Subject: RE: Planning Consultation on: A/37/20/DOC

Engineers Comments Regarding Surface Water Drainage

APPLICATION NO: A/37/20/DOC
Registered: 5th March
2020
Site Address: Land between Ashurst and Badger Ham Manor Way Angmering
BN16 4JQ
Grid Reference: 506315 103858
Description of Works: Approval of details reserved by condition imposed under ref
A/55/19/PL relating to Condition No 4 - surface water drainage

| Drawing Number | 2031/SK2                           |

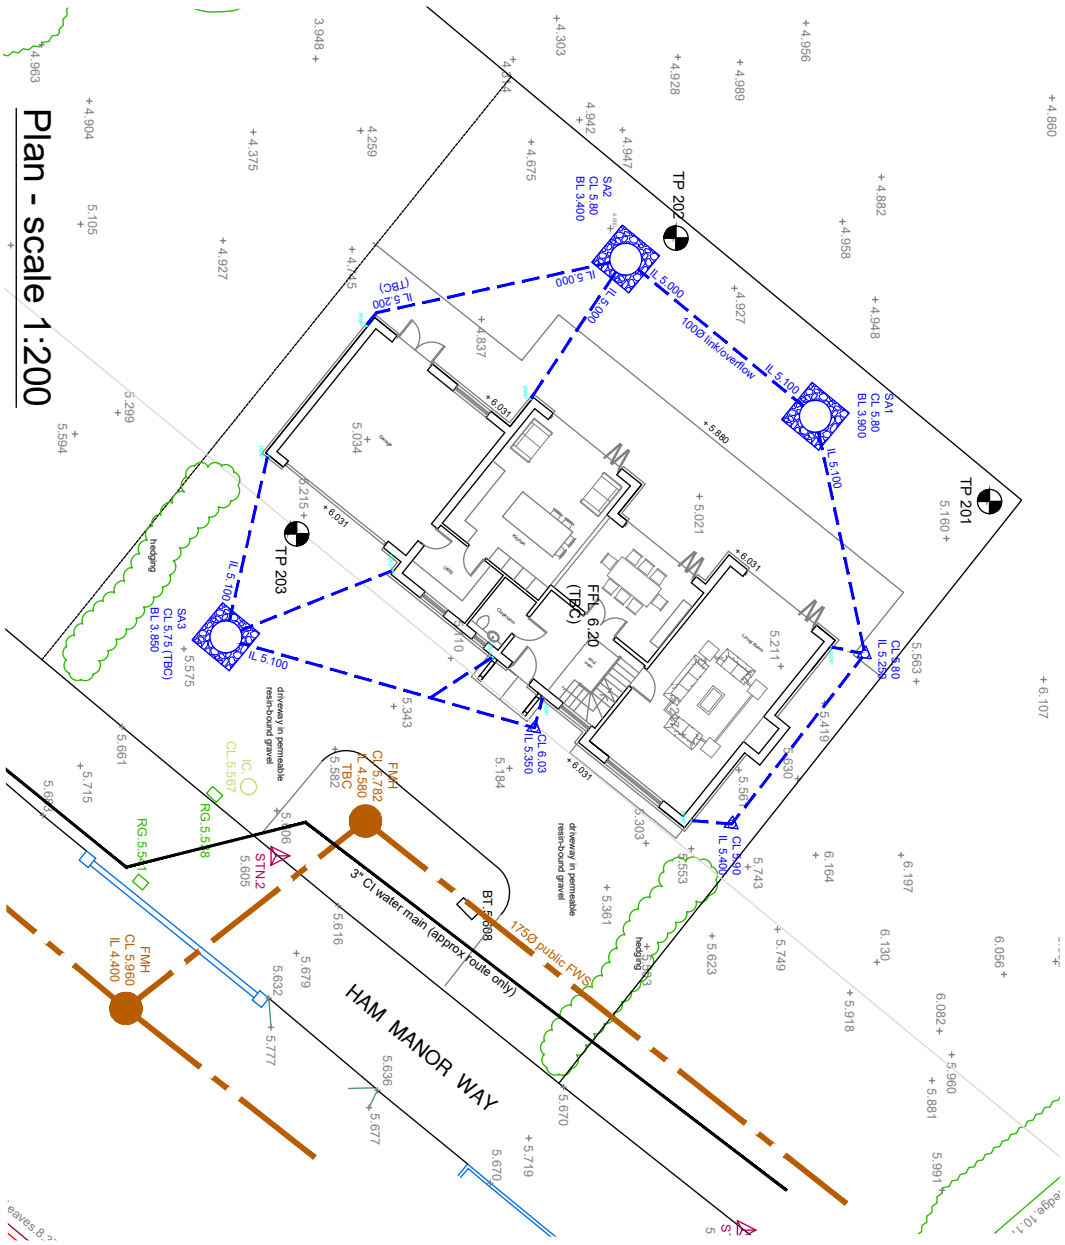
1. Soakaway no.1 near retaining wall is showing top water level (5.206) higher than the ground levels in the adjacent golf course. Perforated rings extend up to 5.000m AOD, just slightly above those ground levels, but granular surround is higher, and the link overflow pipe is set at 5.100. There is spare capacity in soakaway no.2 for when the link pipe operates. We would like to see the link pipe level dropped below the adjacent golf course ground levels, to safeguard any possibility of water finding its way out of soakaway no.1 (before water flows into no.2) i.e. through perforated rings and then into granular surround and then passing through the retaining wall (via weep holes or drains) and into the golf course.

2. Silt traps are needed upstream of soakaways. It is noted that a construction detail is included for an inspection chamber but these are not shown on the layout.

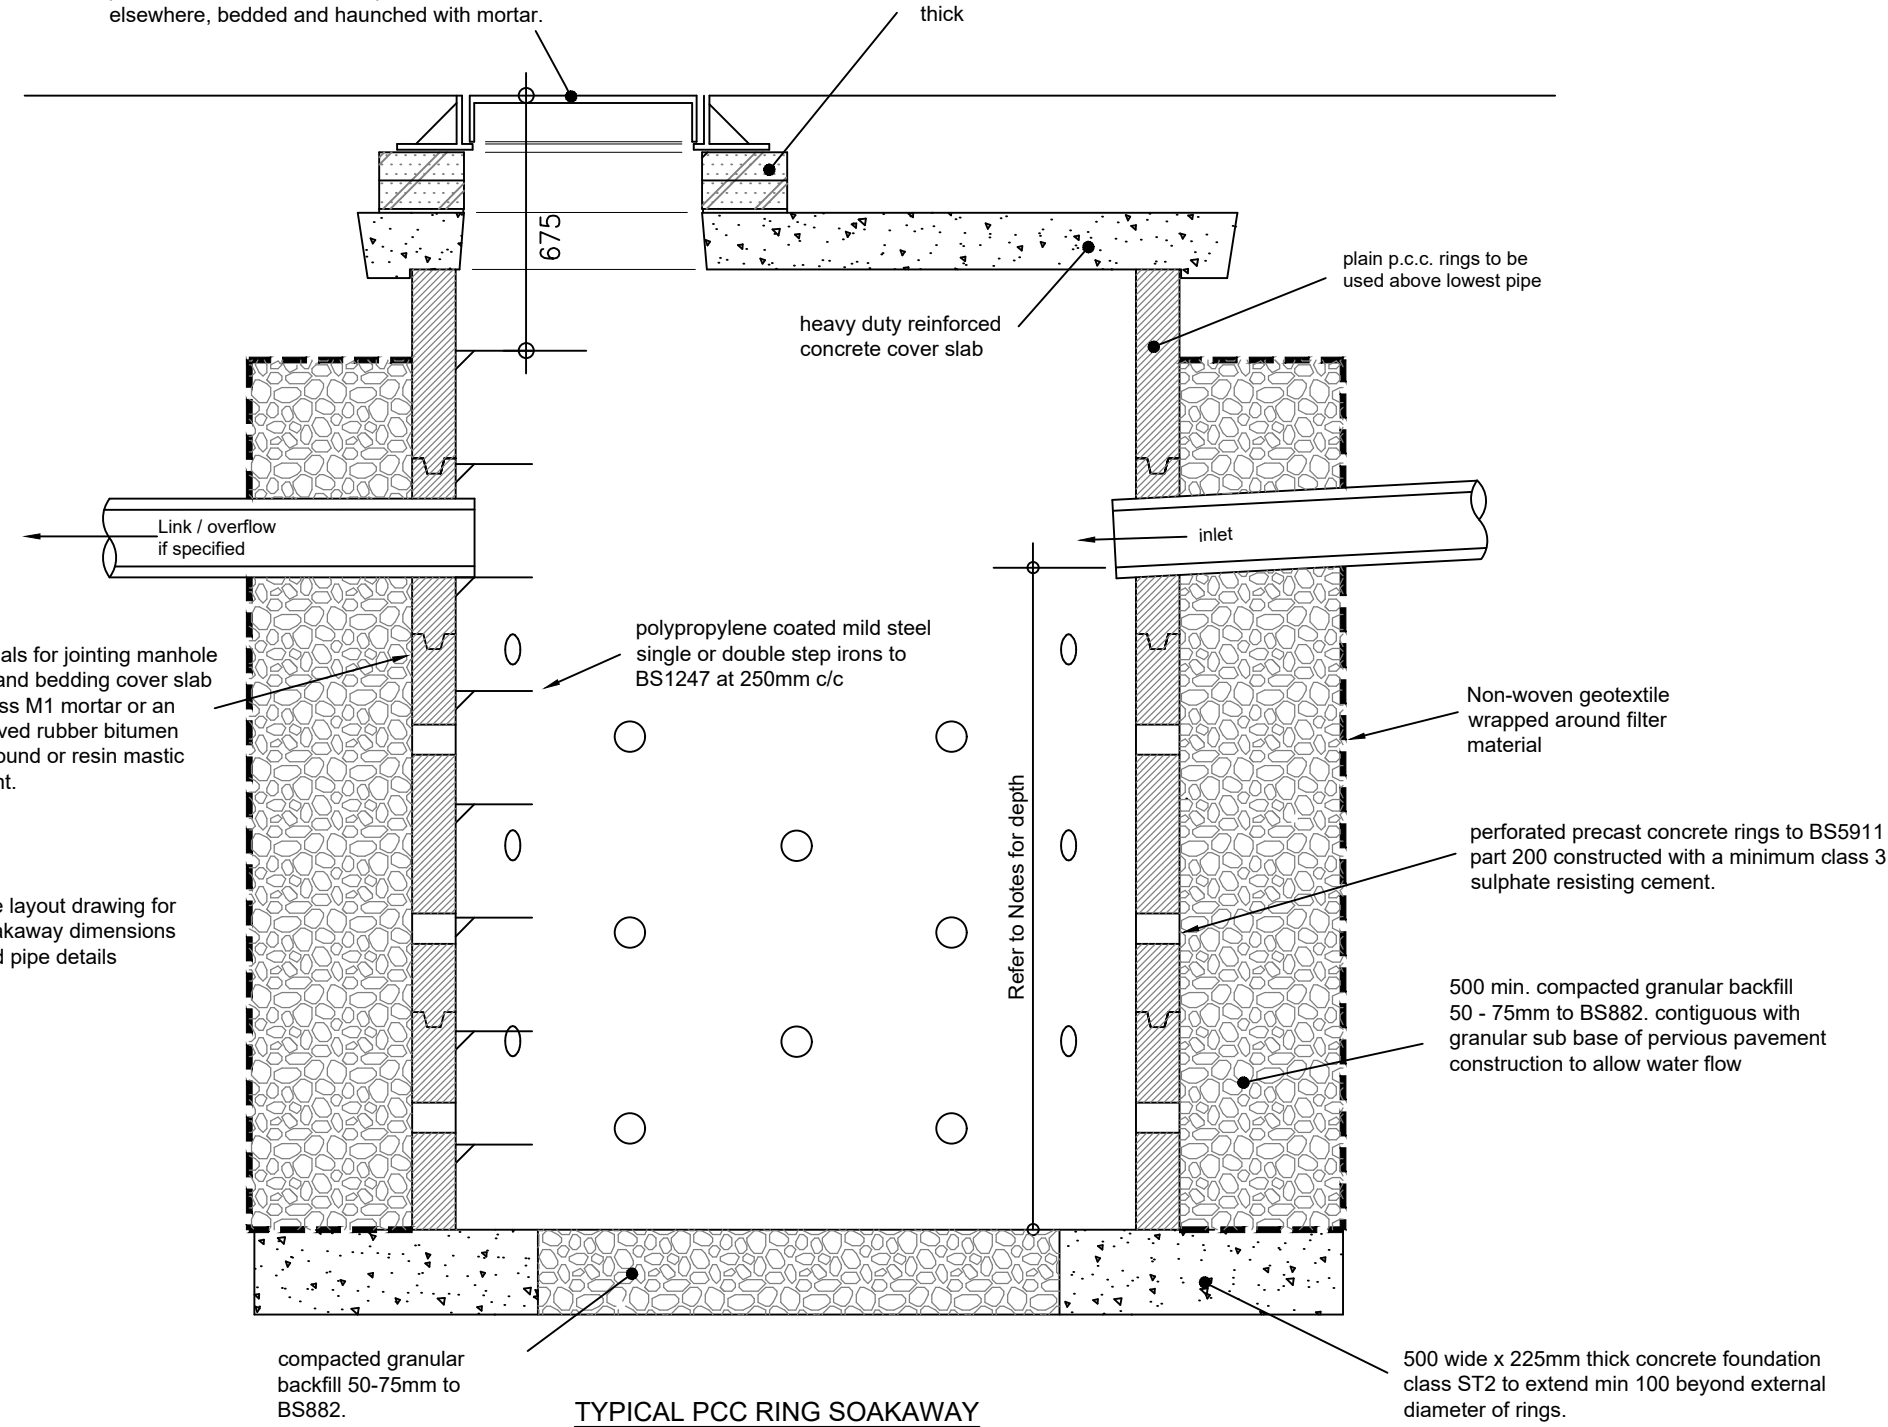
3. Driveway noted as resin bound (porous) but no calculations or construction details have been provided.
4. Construction details are required for:
 - a. Silt traps

- b. Pipe bed and surrounds
 - c. Driveway
 - d. Section of retaining wall to show it's drainage
5. It appears that ground levels are only being raised around the building and not the land to the south. However, from what we can see in terms of levels, the proposed raising of ground levels is going to conflict with the flow path/storage. The applicant needs to indicate what they believe to be the flow path/storage on their drawings so we can discuss this further and ensure that the flow path is not being diverted on to neighbouring properties and that the natural storage on the site is compensated for.
